REVISED DRAINAGE REPORT  
FOR  
TUSCANY RIDGE UNIT 2  
NOVEMBER 20, 1998

RE: COMMENT RESPONSES - TUSCANY RIDGE UNIT 2  
DRB #98-363

Addendum to the Drainage Report for Tuscany West Subdivision, Units I & II (A11/D11)  
Comments dated November 17, 1998

**Drainage Report and Grading Plan for Tuscany Ridge, Unit 2 (A12/D15)**  
Comments dated November 17, 1998

PLATE 1

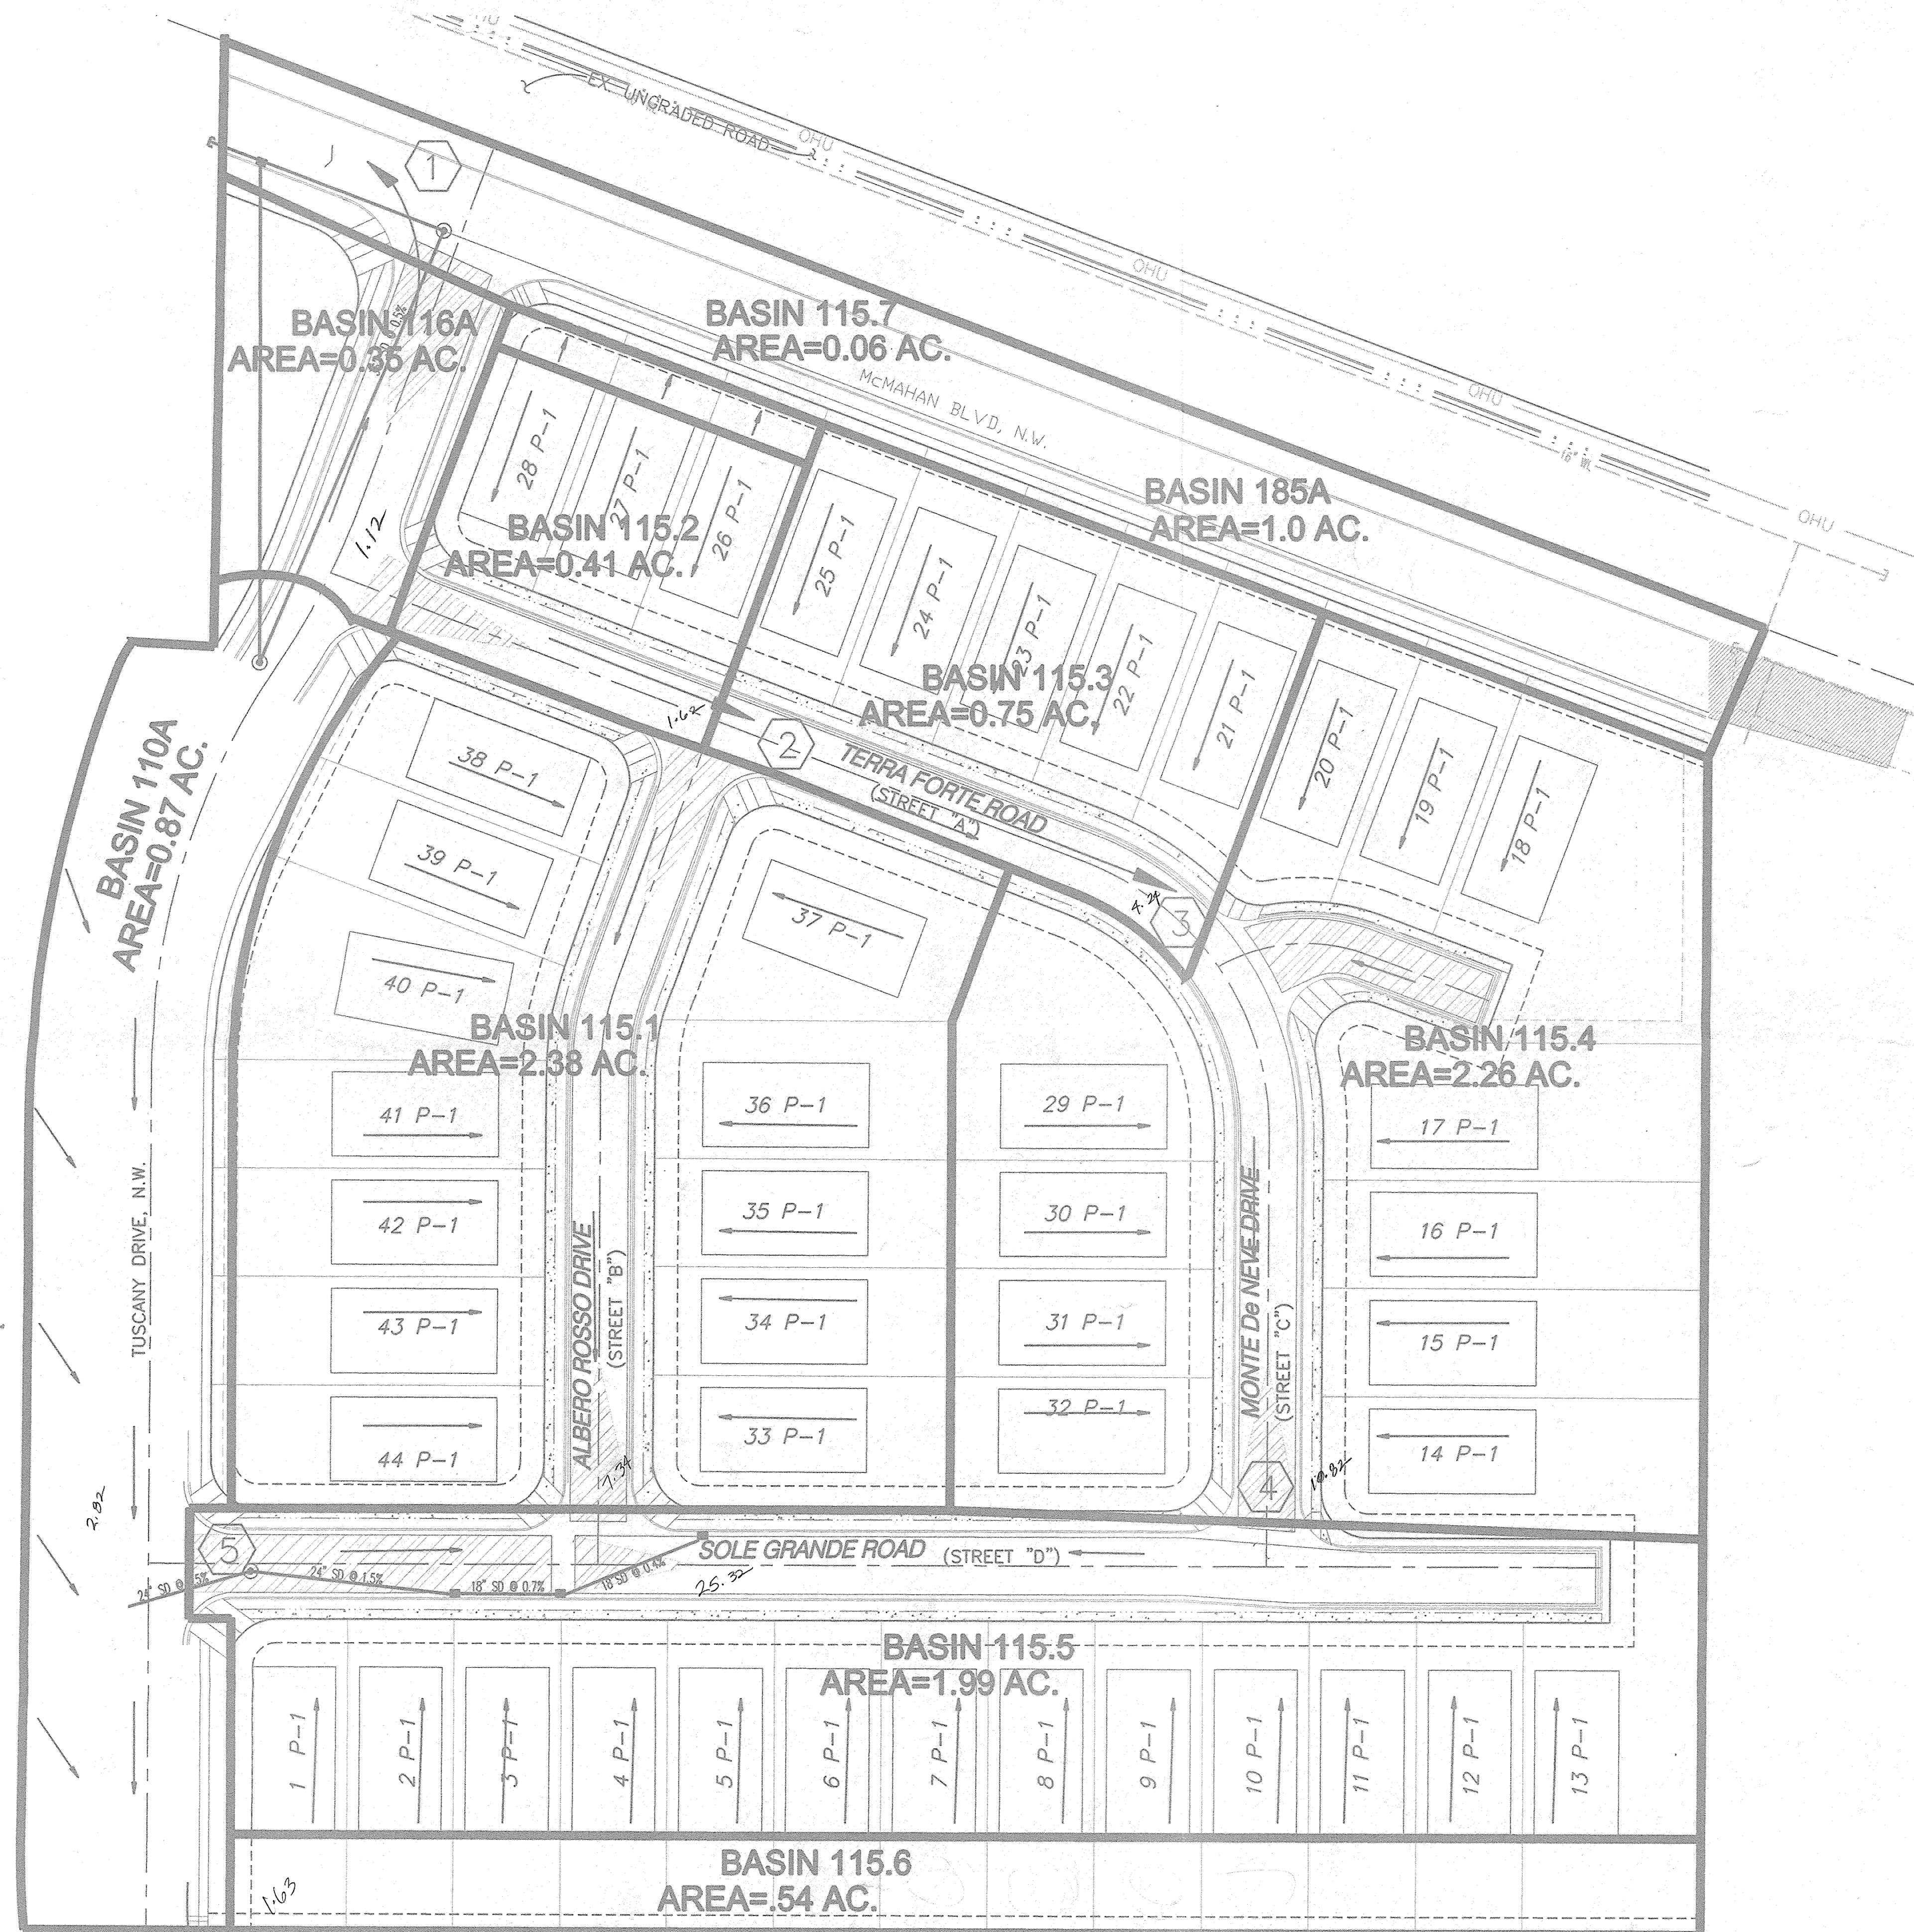
**Comment No. 3** The grading plan and drainage report is revised to drain the entire lot, except backyards, to the front. The backyards drain to a private drainage easement and rundown.

**Comment No. 4** In an effort to minimize earthwork costs and reduce retaining wall heights, the inlets are placed in a sump. The sump is only slight. Should the inlets fail or should a storm event greater than the 100-year occur, the runoff would overtop the sump and outfall to Tuscany Rd. before overtopping the curb.

**Comment No. 8** The existing catch basins have been added to the plan. These basins do intercept flow from basin 110A.
